SUBJECT: **Section 401 Minor Tear Sheet Permit Modification Request** for Widening of Davis Drive (SR 1613/SR 1999) from Morrisville-Carpenter Road in Wake County to NC 54 in Durham County, State Project No. 9.8051713, TIP No. U-4026, Work Order 9.8051713, WBS Element 35018.1.1

The purpose of this memo is to request a minor tear sheet modification to the above-mentioned permit and to provide updated permit drawings for the above mentioned Water Quality Certification.

After reviewing the final construction drawings, one discrepancy has been found at the relocated channel near station 285+00 Rt and is described below.

PROJECT REFERENCE NO. U-4026	SHEET NO. 2-BB
R/W SHEET NO.	
ROADWAY DESIGN ENGINEER	HYDRAULICS ENGINEER
PRELIMINARY PLANS DO NOT USE FOR CONSTRUCTION

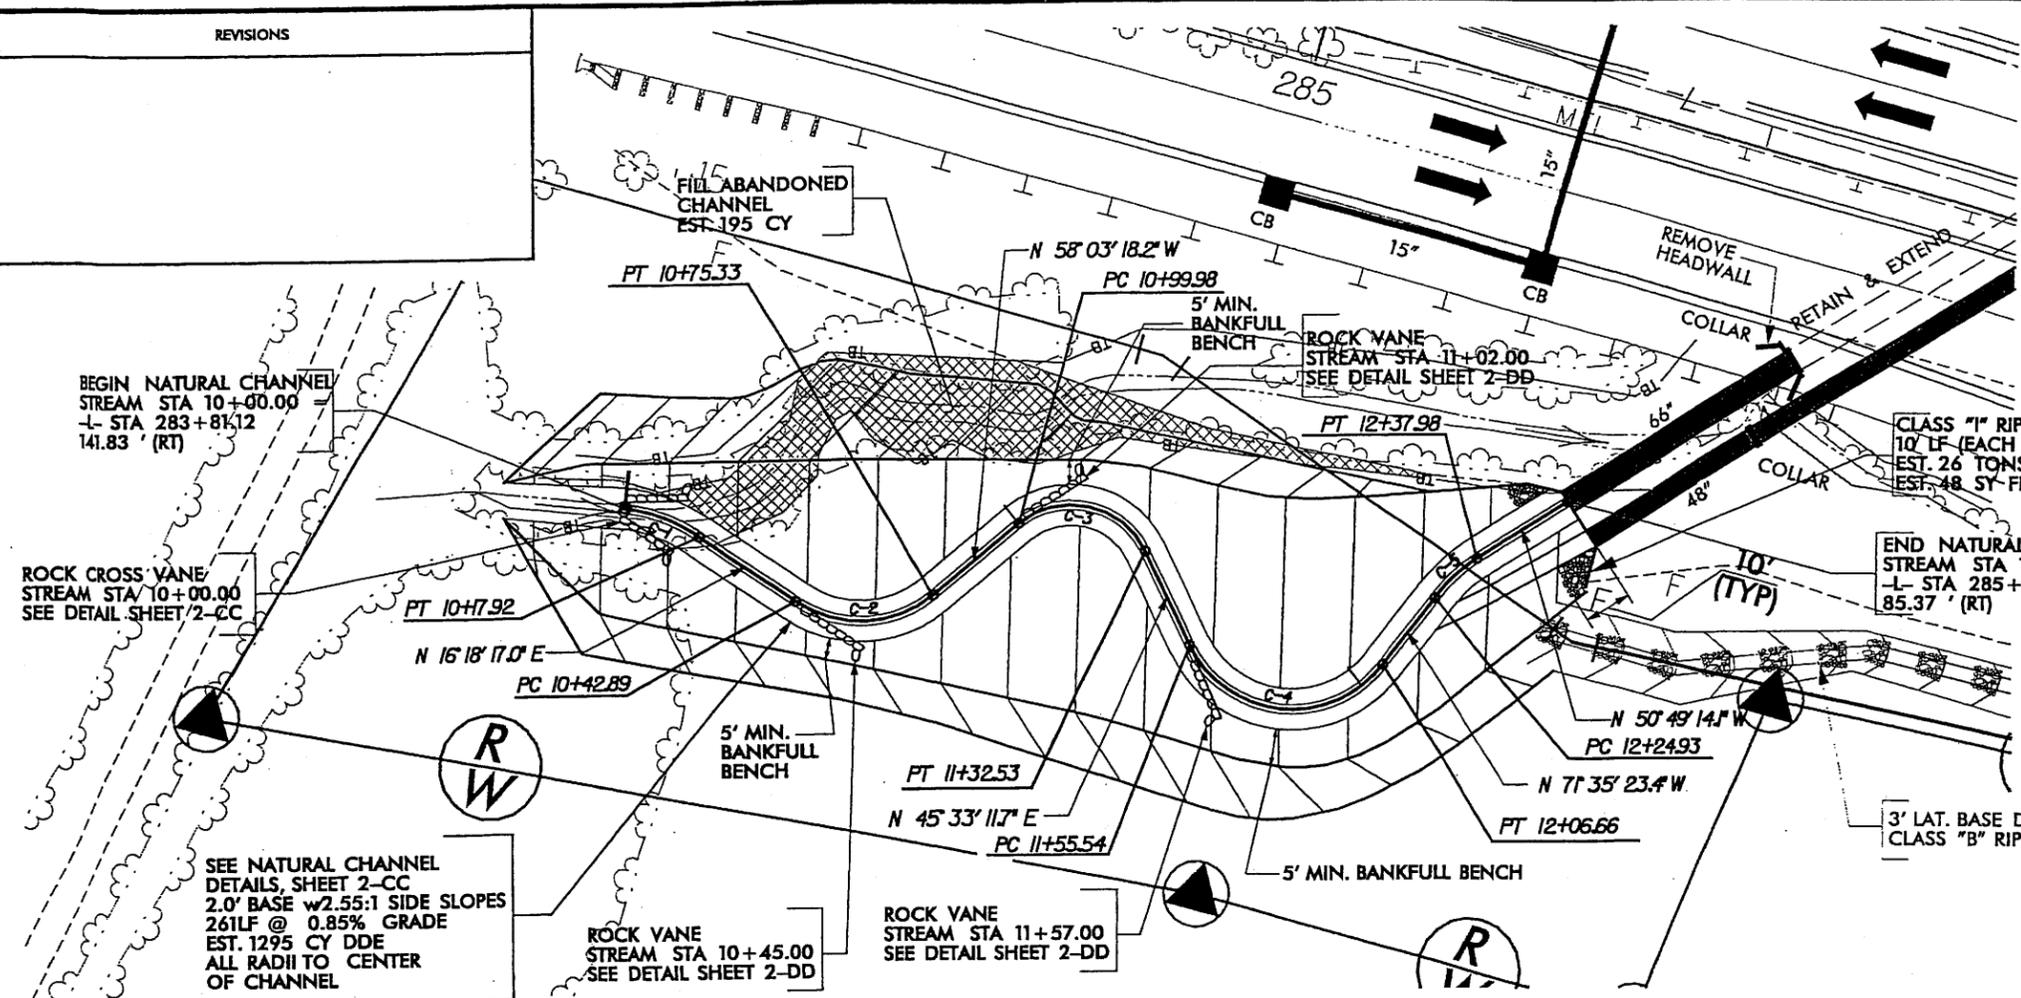
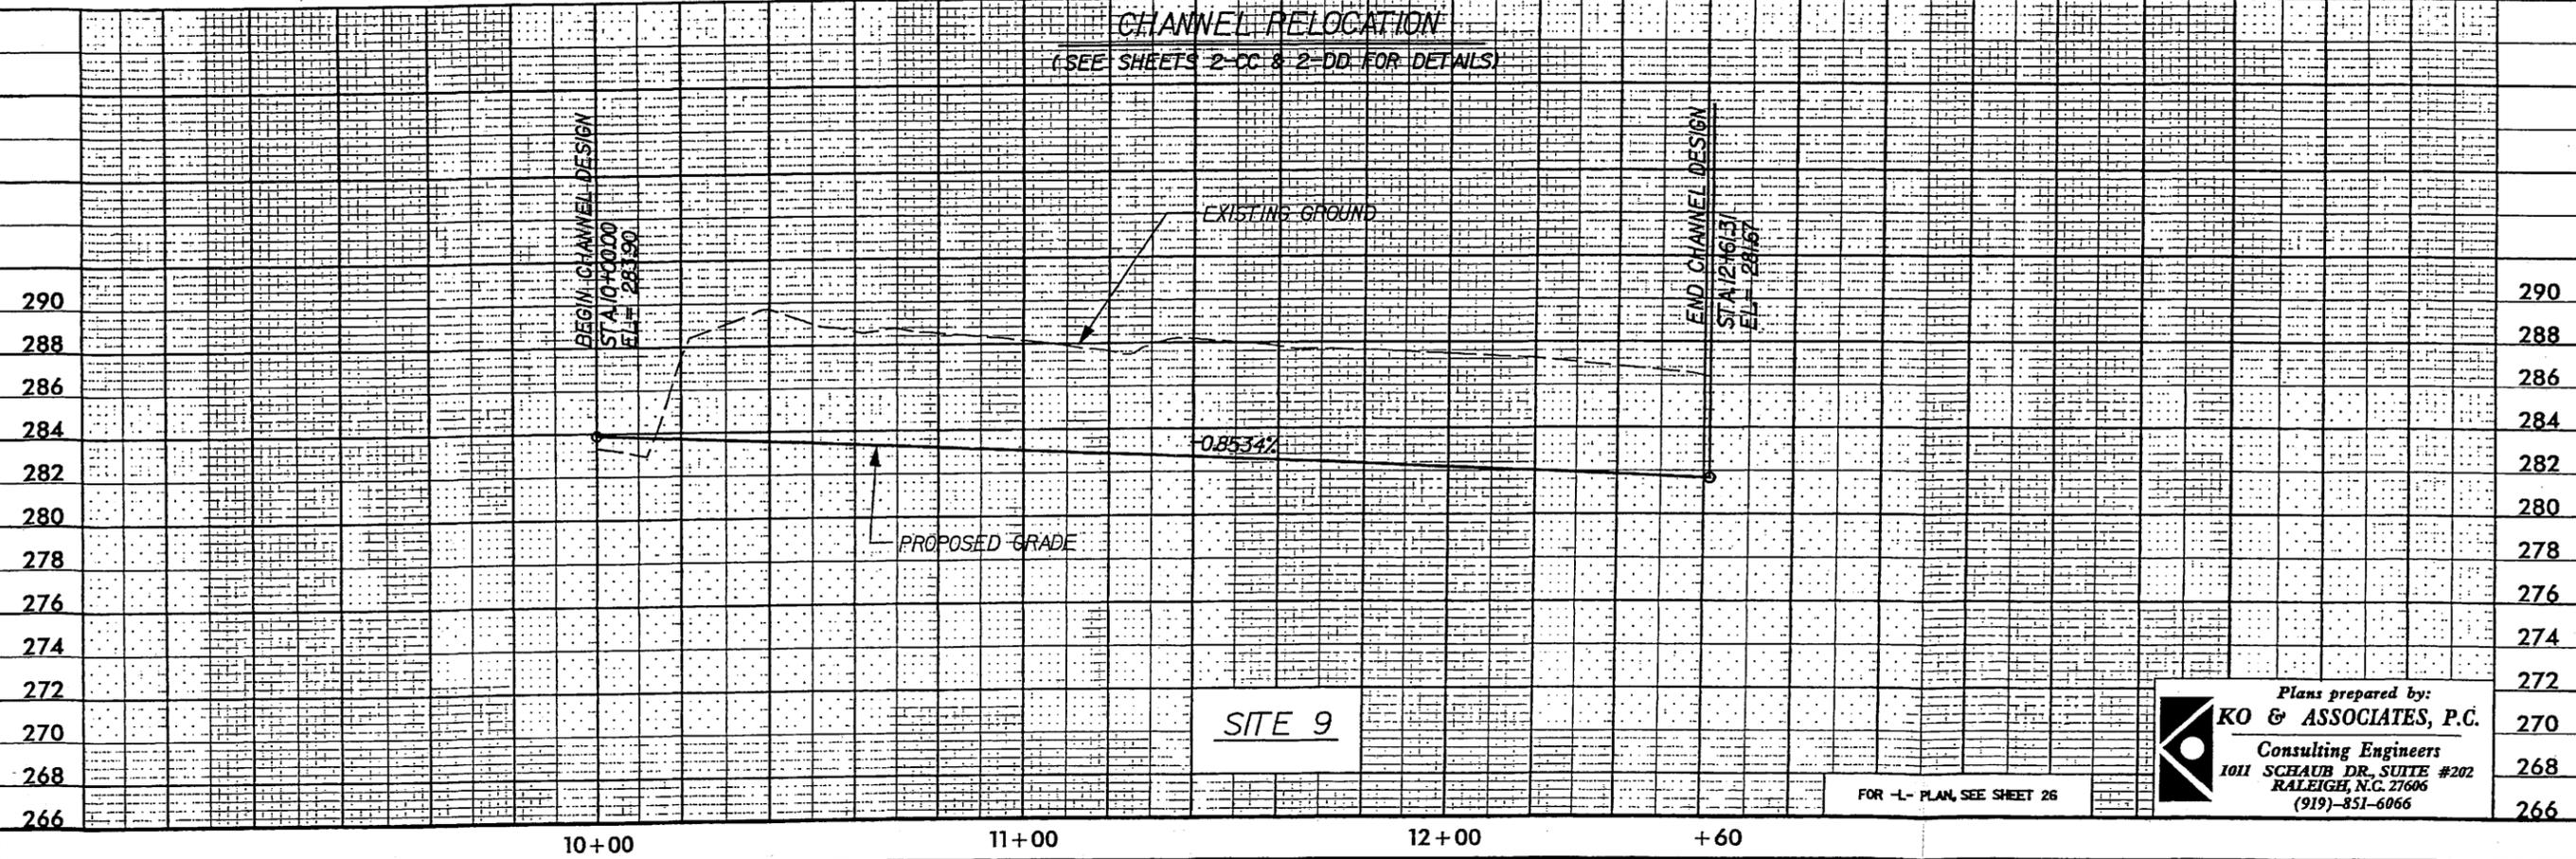
Plan sheet 2-BB depicts a rock cross vane at 10+00, rock vane at 10+45, j-hook vane at 11+00 and rock vane at 11+52. The sheet notes that the details for these devices are located on sheets 2-CC and 2-DD.

Permit Drawing 42 of 65 (that reflects plan sheet 2-BB) depicts a rock cross vane at 10+00, rock vane at 10+45, rock vane at 11+02 and rock vane at 11+57.

The permit drawings have been revised to match the final construction plans. No additional impacts to jurisdictional resources occur. Condition 19 of the Water Quality Certification states
